STAFF REPORT

WHITE WATER PERFORMANCE BASED CLUSTER PLAT

TO: Kittitas County Hearing Examiner
FROM: Kittitas County Community Development Services Staff
RE: White Water Performance Based Cluster Plat (LP-08-00028)
DATE: May 27, 2010

**WHITE WATER**  
**PERFORMANCE BASED CLUSTER PLAT**  
 PTN. NORTH 1/2, SECTION 1, T.19N., R.15E., W.M.  
 KITTITAS COUNTY, STATE OF WASHINGTON

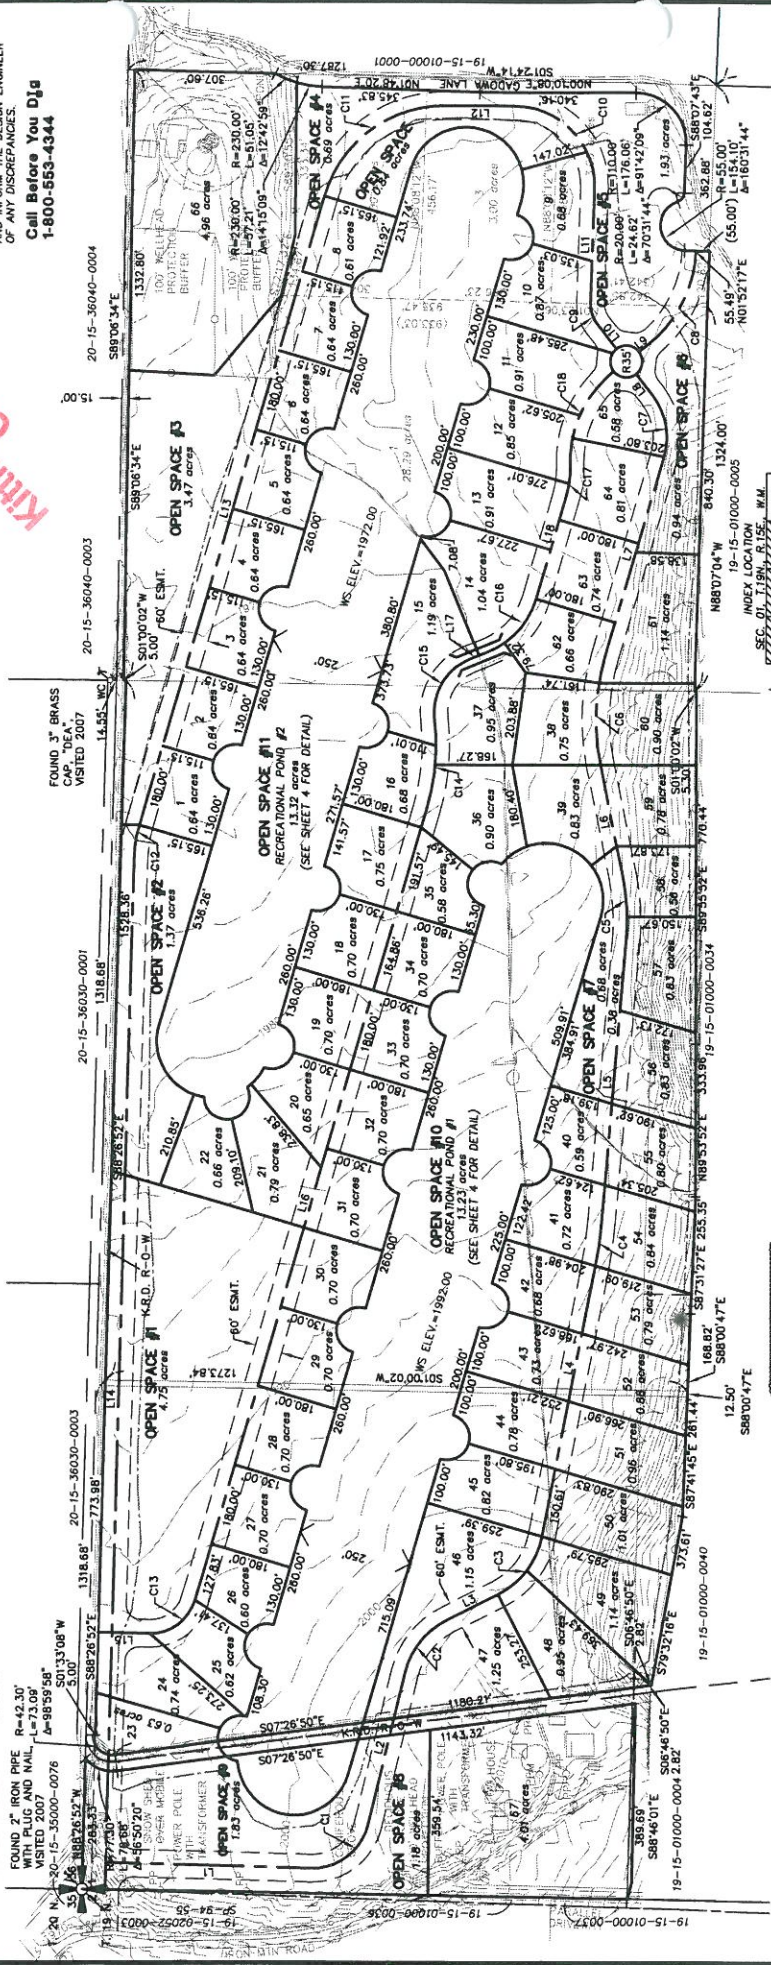
16. Lot 24: Access shall be provided to Lot 24.
17. Godawa Lane Spelling: Godawa Lane shall be spelled correctly on all documents. It is currently spelled incorrectly on Sheet 2 of the plat.
